OUT19/15798

**WestConnex M4-M5 - Mod 3 - Iron Cove ventilation underground (SSI-7485-Mod-3)  
Environmental Assessment**

Figure 1 Alignment of proposed new ventilation tunnel and caverns at Iron Cove

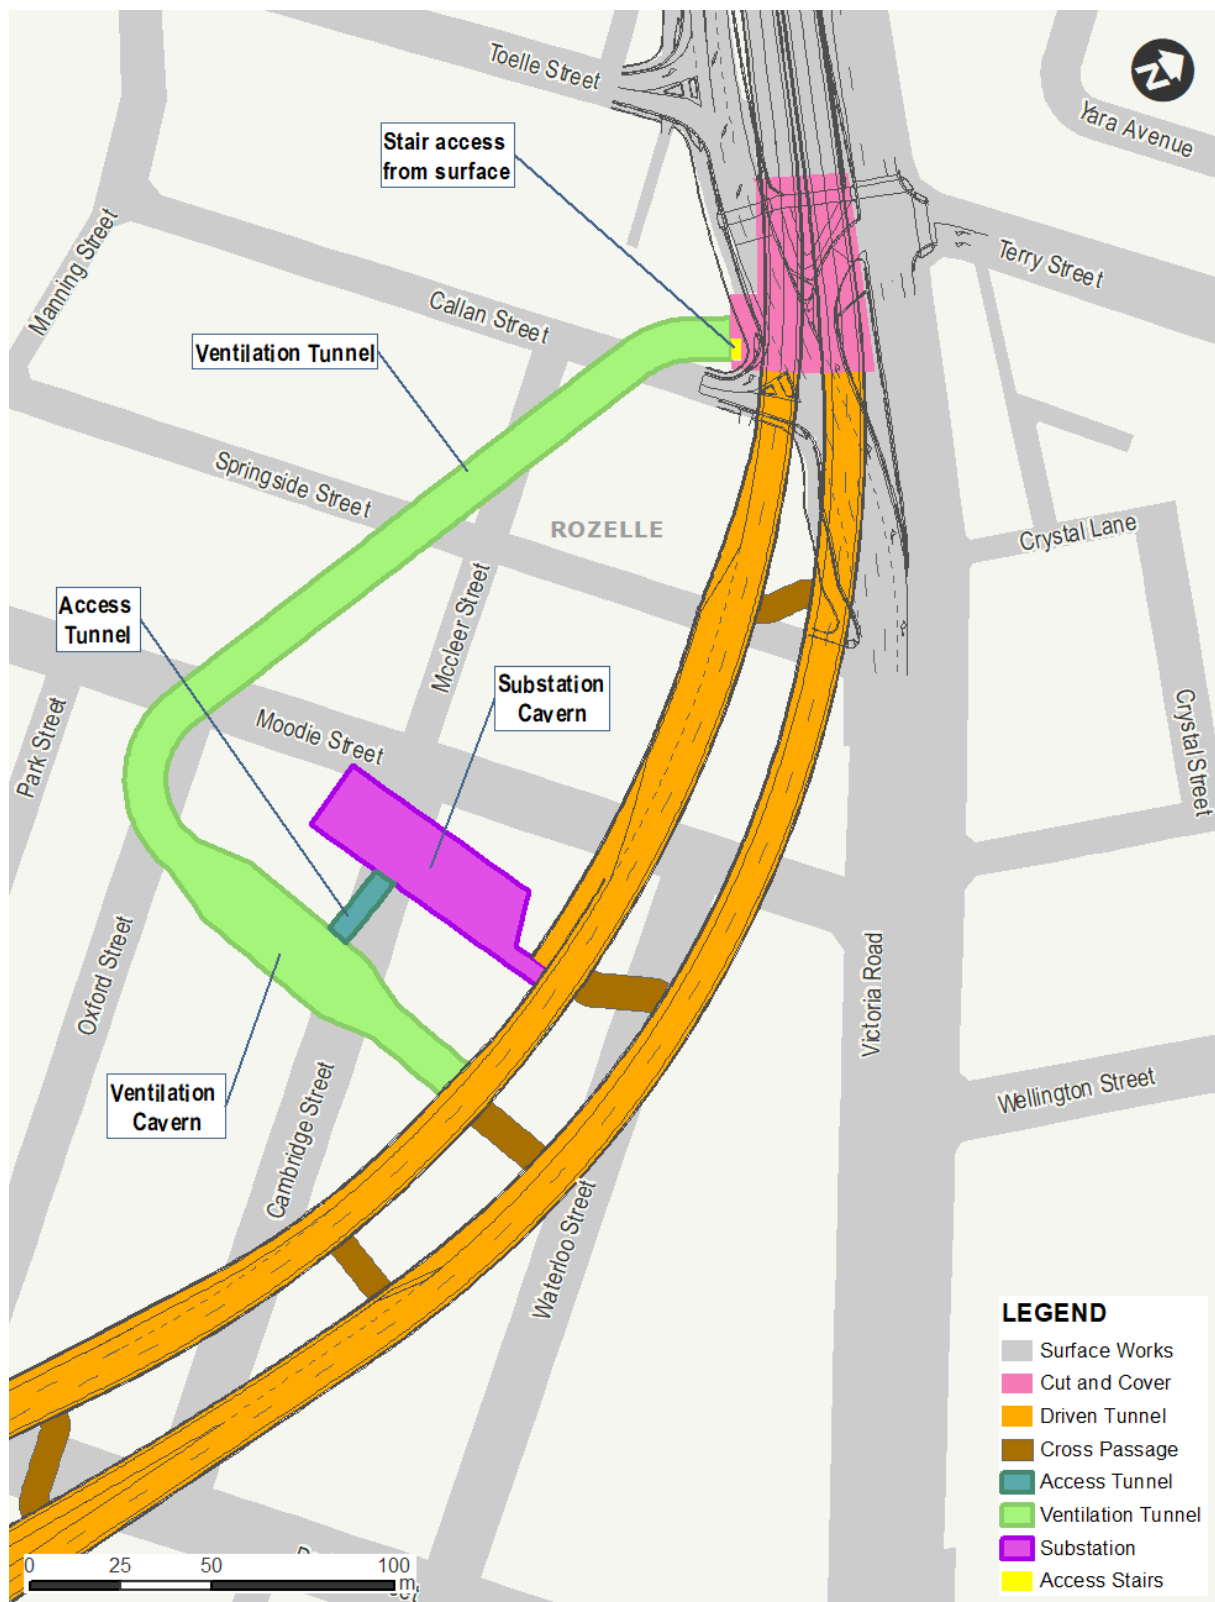
The potential extra impacts related to groundwater drawdown imposed by the additional 425 m of tunnels/caverns in the area between the construction and Iron Cove has not been adequately assessed. This can be addressed by including the new construction works within the existing numerical groundwater modelling.

Furthermore, additional groundwater monitoring bores are required to the west of the proposed construction. Monitoring results should be interpreted in terms of “Site Specific Trigger Values” and other means already incorporated in the M4-M5 Link (Rozelle Interchange) Groundwater Monitoring Plan.

- Within six months of approval, the details of the new construction should be incorporated in the latest iteration of the project groundwater numerical model. Then, appropriate predictive analysis should be run for the model and the outcomes, and any potential necessary responses, be discussed with and reviewed by DPIE Water.
- Within six months of approval, additional groundwater monitoring bores to the west of the construction should be installed and the appropriate Groundwater Monitoring Plan should be updated accordingly, and reviewed by DPIE Water.
